Ref: Huntlee New Town - Stage 2 - SSD-70748466

We are writing to formally object to the proposed development project Huntlee Stage 2, Residential large lots located at Old North Road, South of Huntlee Village.

DRAWING TITLE  
**CIVIL SKETCH**  
**CONCEPT STORMWATER MANAGEMENT SITE PLAN**

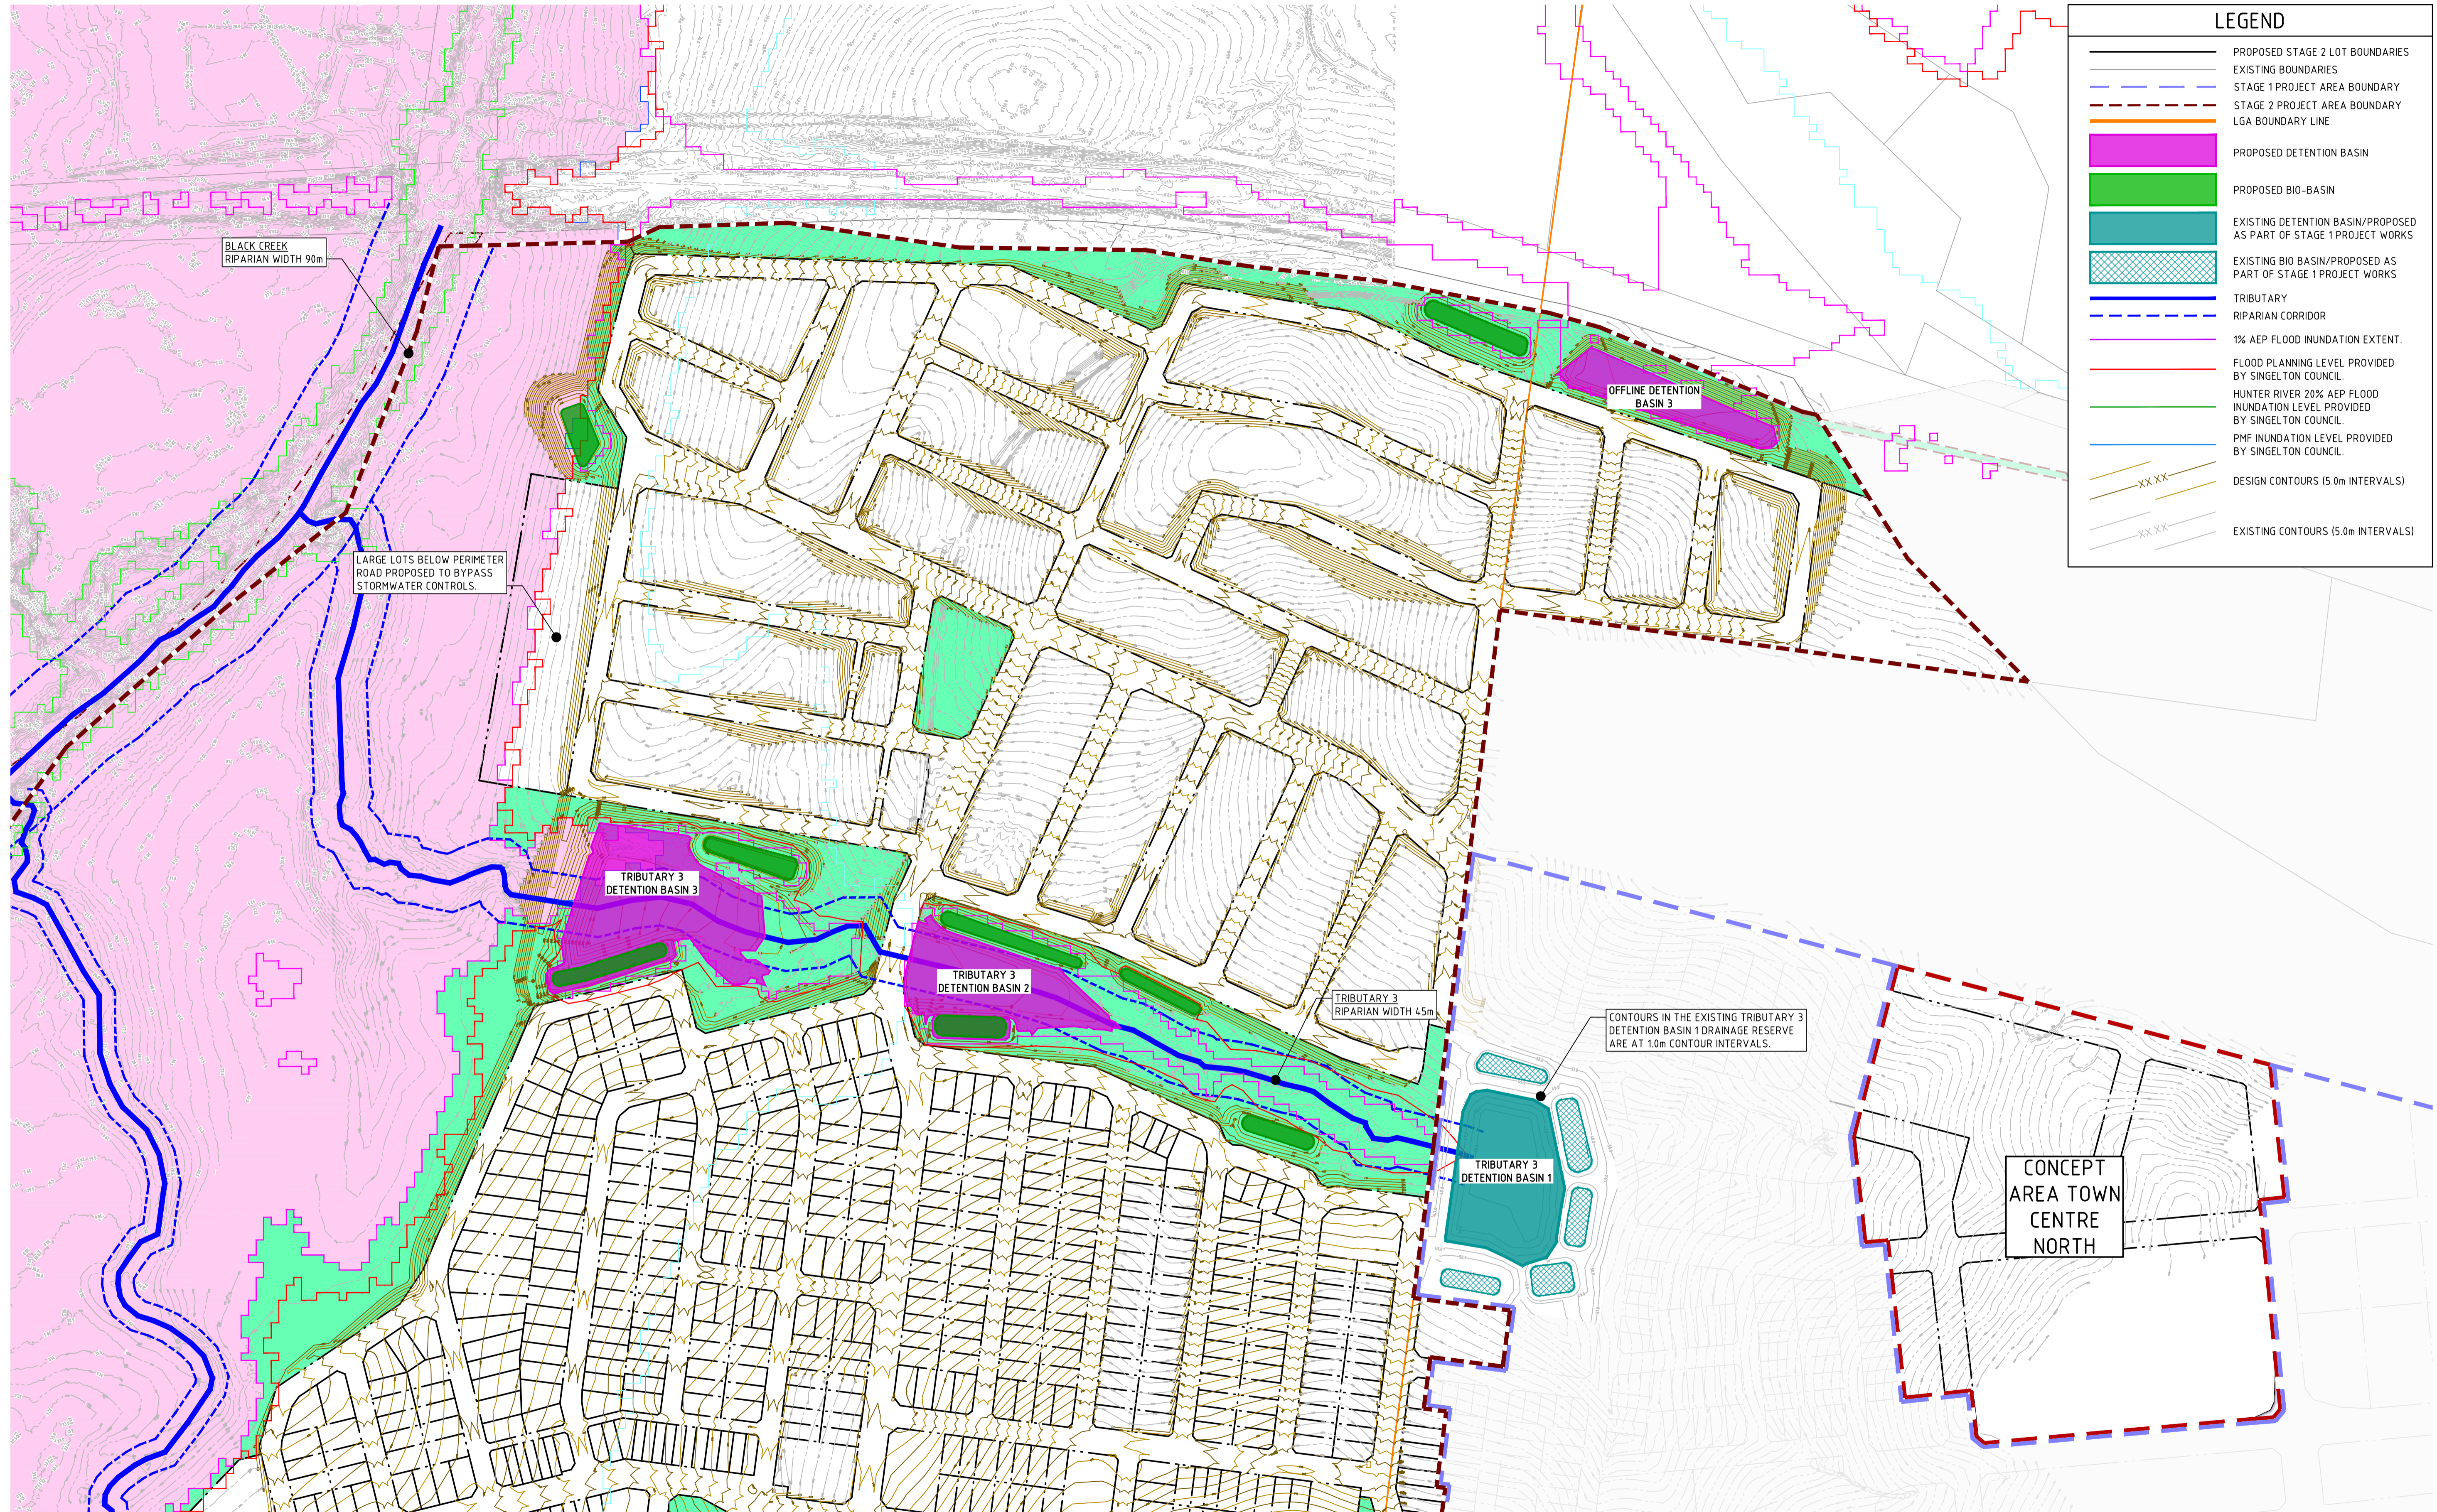
In the current documentation there is no mention of the impact of the residential large lots development on the management of Storm Water in the area.

Our concern is where will the rain/storm waters be directed as this will have a major impact on the rural/vineyard properties downstream, changing the way rain and storm waters are currently available and managed.

1. Preventing reduction or excess of water on the rural/vineyard properties downstream.
2. Preventing ground water pollution during the construction phase

PROJECT	DRAWING TITLE	JOB NUMBER
HUNTLEE STAGE 2 DA AREA OLD NORTH ROAD	CONCEPT CIVIL ENGINEERING PACKAGE STAGE 2 DA OVERALL SITE PLAN	NL220566
		DRAWING NUMBER ONRC-C01.11
		REVISION A
		DRAWING SHEET SIZE = A1

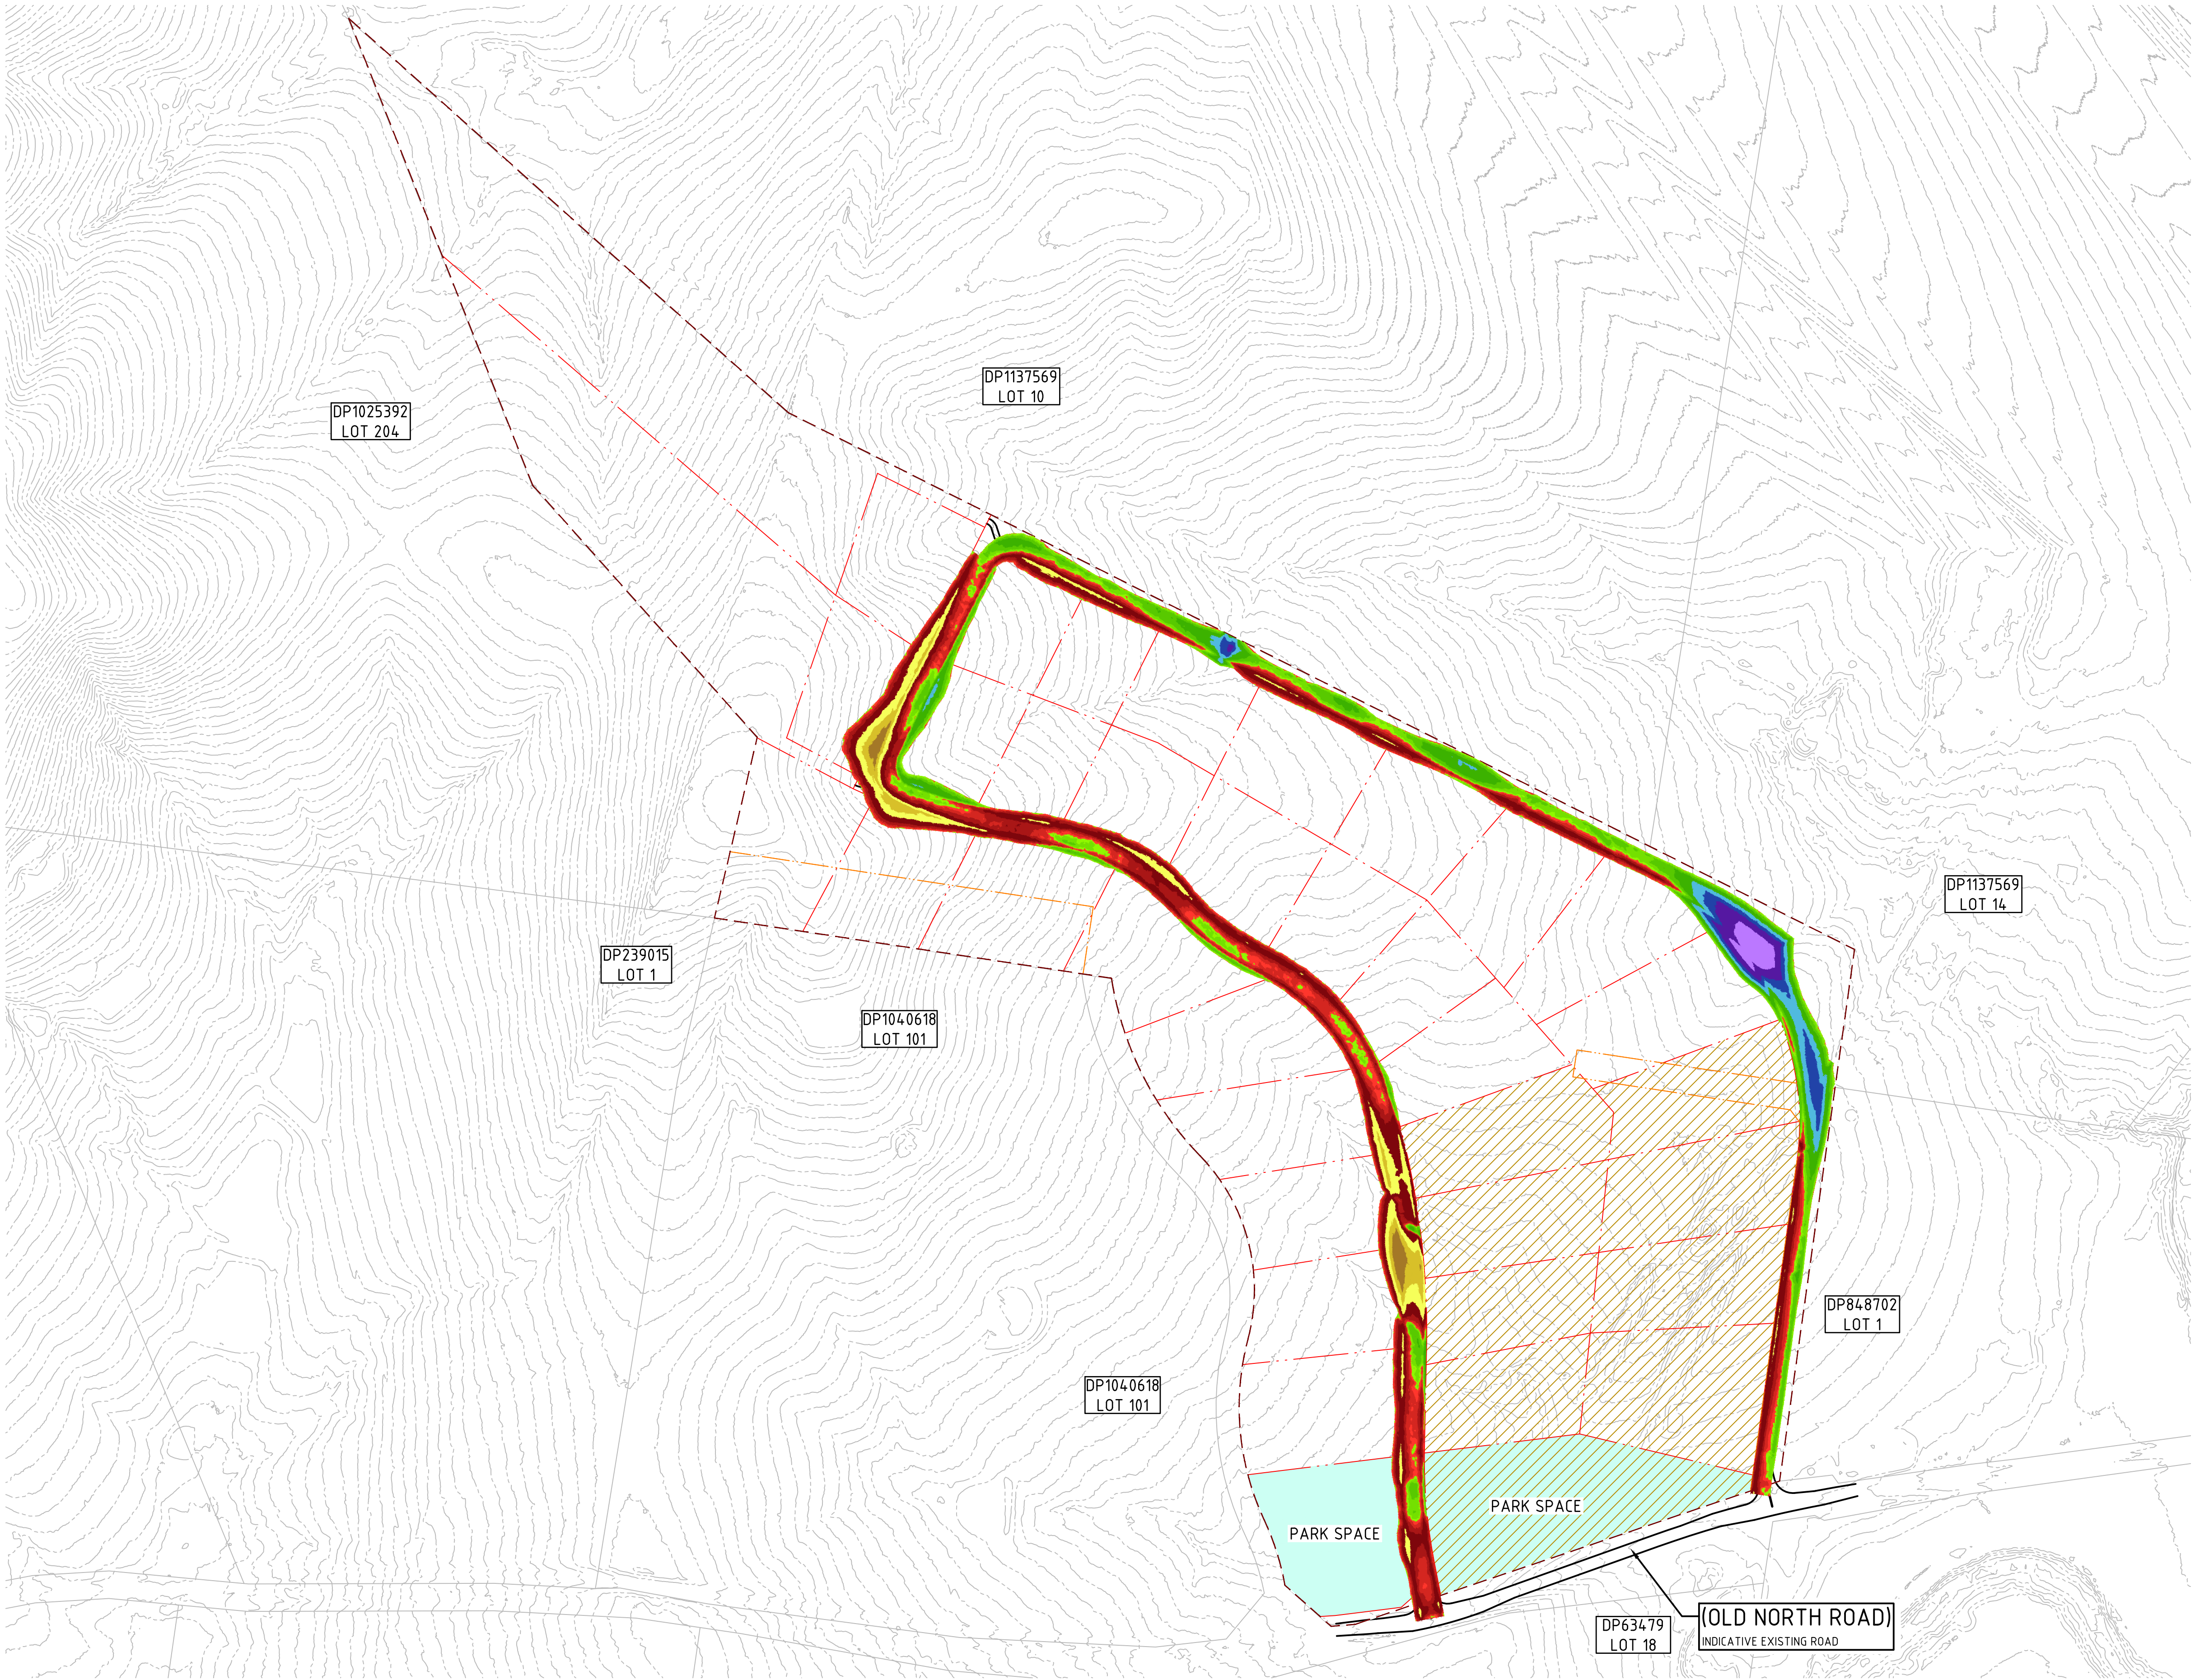
The Old North Road Large Lots documentation states that Old North Road will be sealed (Doc J5 Indicative Old North Road Concept Area page 10), but there is no mention of improving the Black Creek Causeway to access Wine Country Drive.

The current state of the ONR dirt road (4.9km unsealed) and Black Creek causeway present several challenges and hazards to residents and motorists alike. During periods of rain (not even heavy rain), the causeway becomes submerged, posing major risks to the safety of residents, commuters and visitors in the area.

In addition the Black Creek causeway has already become inadequate for the level of traffic going through this road and is not safe for any increased traffic generated by new residential large lots development on Old North Road.

- a) the upgrade of the intersection between Wine Country Drive and Old North Road
- b) the sealing of Old North Road
- c) the upgrade of Black Creek causeway infrastructure to enable a safe access even in case of at least 20mm to 100mm rain. For instance, 2 to 3 meters elevation of Black Creek causeway should address most of the recurring small flooding events and ensure access to Wine Country Drive
